***Planning Department  
Transportation Development Services***

March 10, 2015

**Re: Pasadena Office Warehouse**  
**5656 Pasadena NE**  
**Traffic Circulation Layout**  
Engineer's/Architect's Stamp dated 7/14/14 (B18-D019)

SITE PLAN

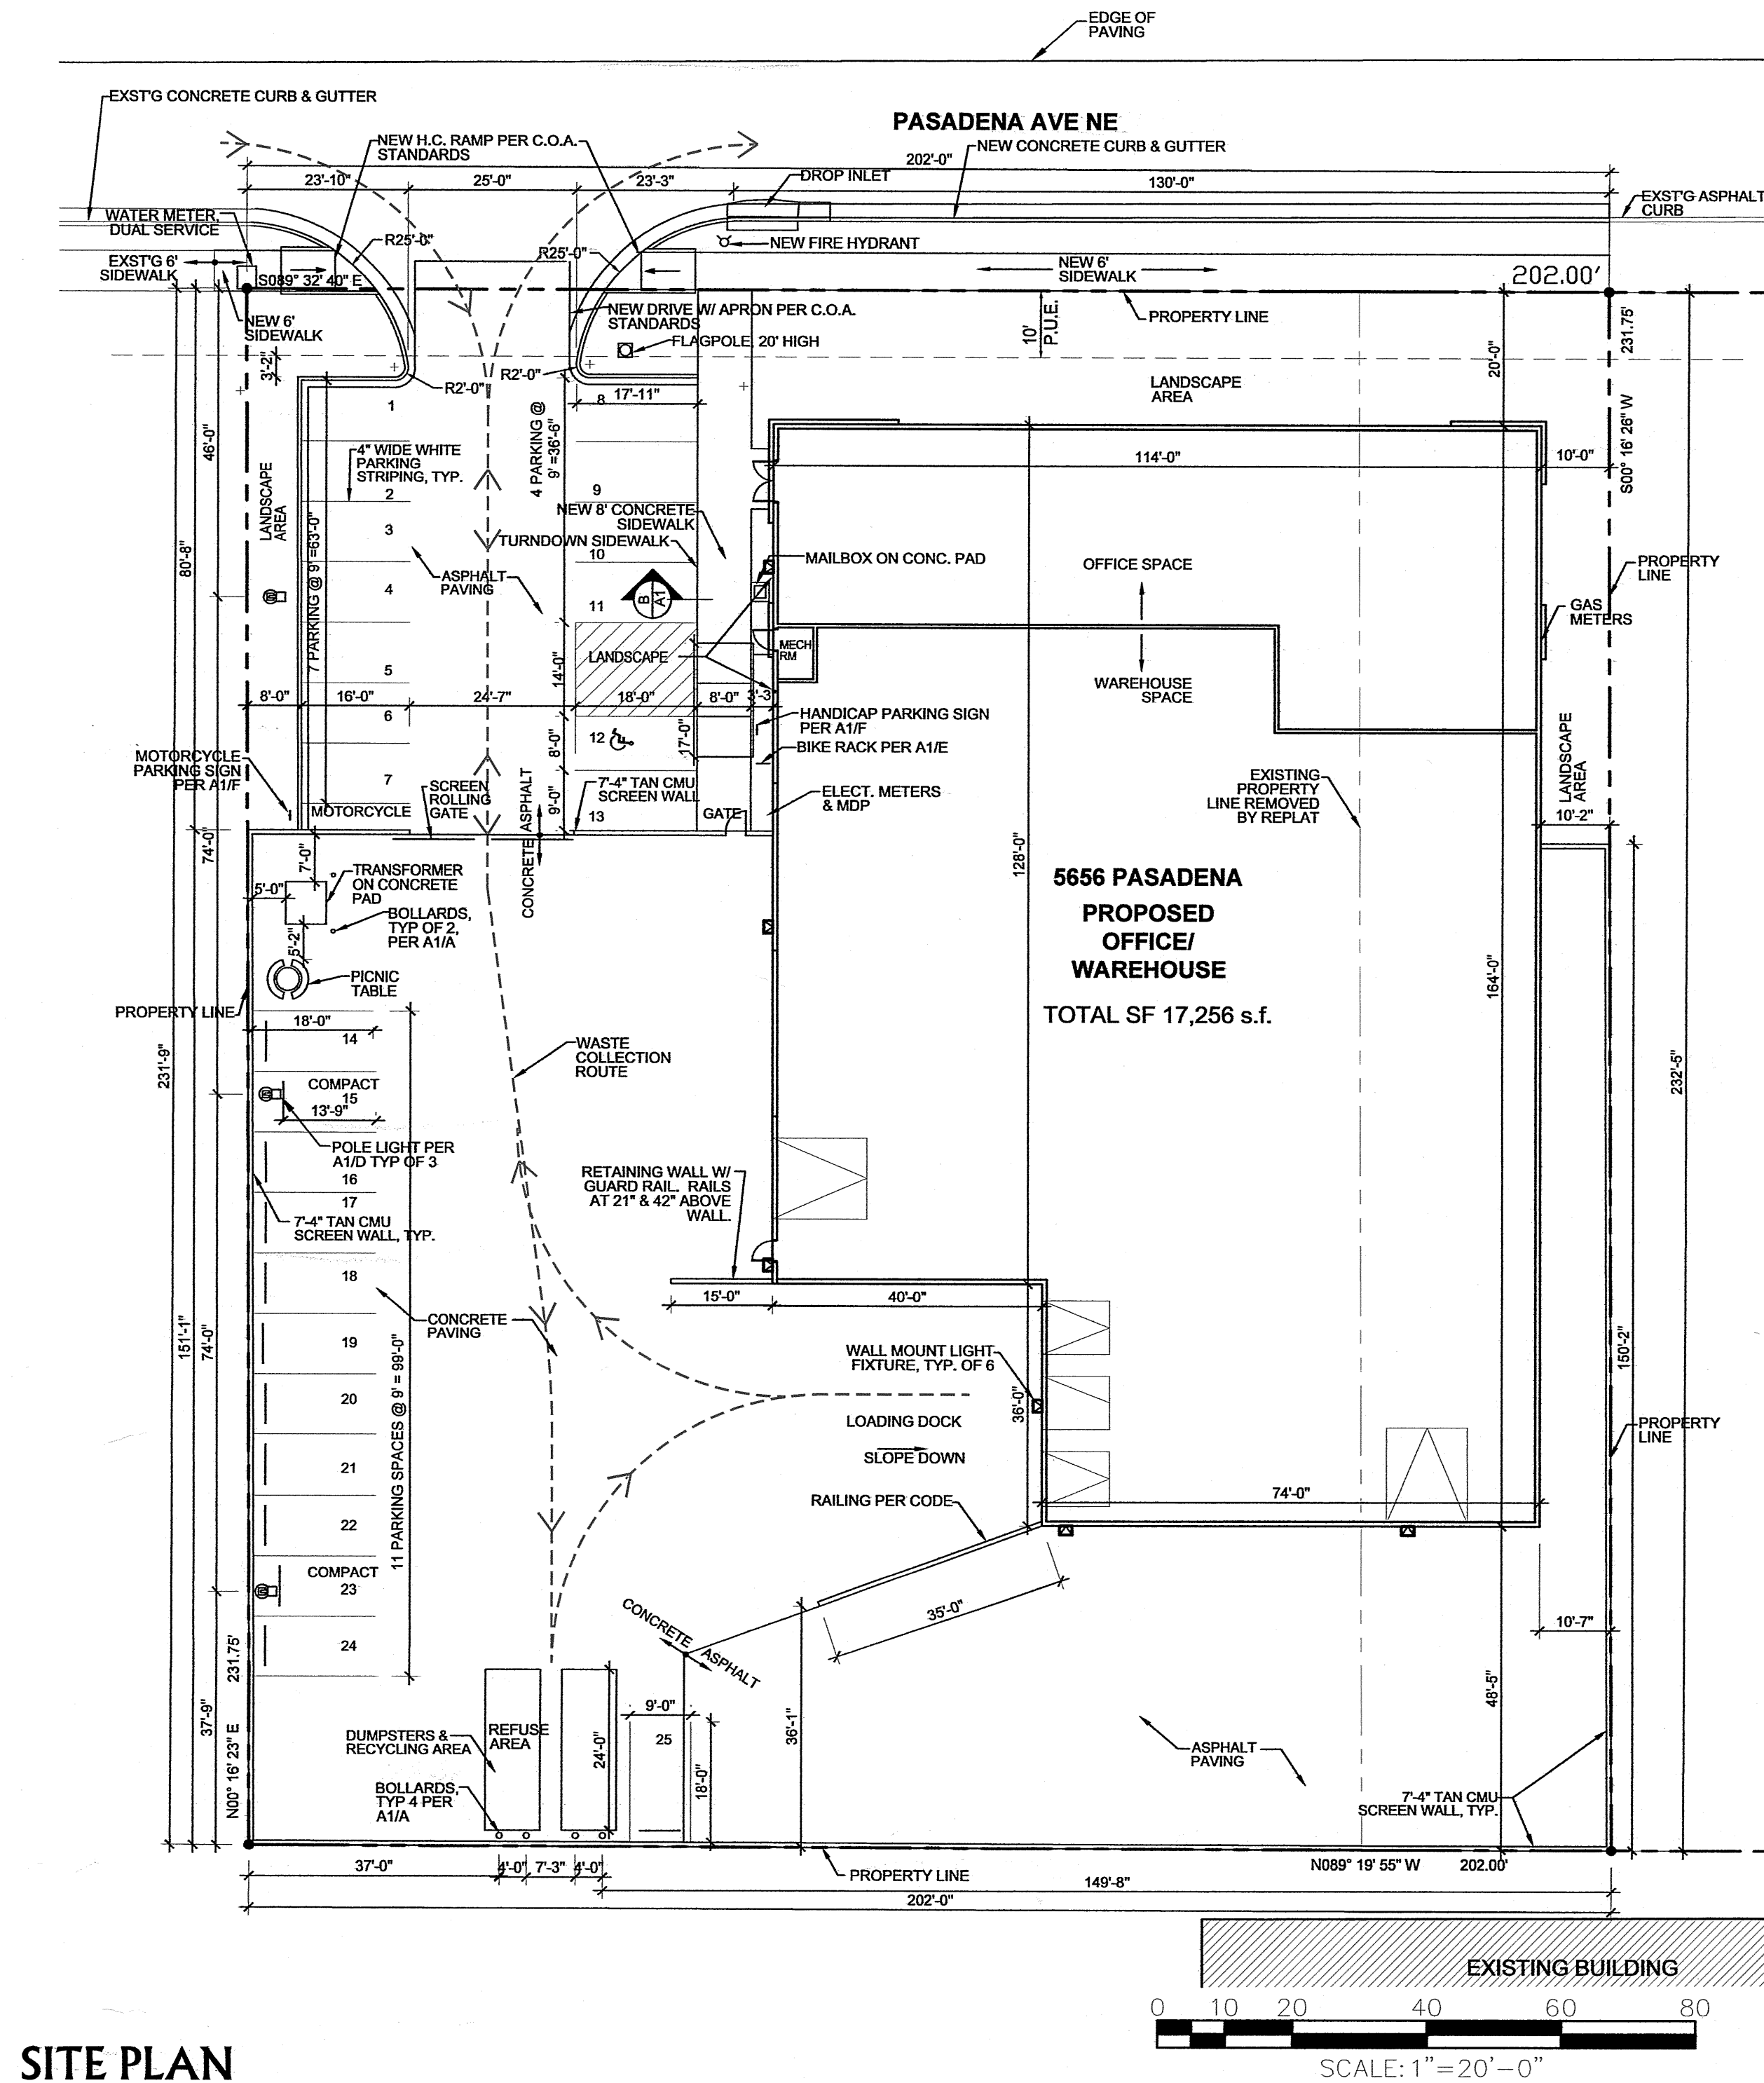
1. Please include written letter of Transportation Certification.
2. The handicap accessible spaces must include an 8-foot wide van access aisle; all other aisles should be 5 feet in width. The van accessible aisle must not be blocked in any way. Upon inspection, there were two bollards at the front end of van accessible aisle.

3. The ADA van accessible sign must have the required language per 66-7-352.4C NMSA 1978 "**Violators Are Subject to a Fine and/or Towing.**"
4. Per the DPM, a 6 ft. wide ADA accessible pedestrian pathway is required from the public sidewalk to the building entrances. Upon inspection, this pathway is not provided. There is a stepped walkway from the public sidewalk to the building entrance. See picture below:
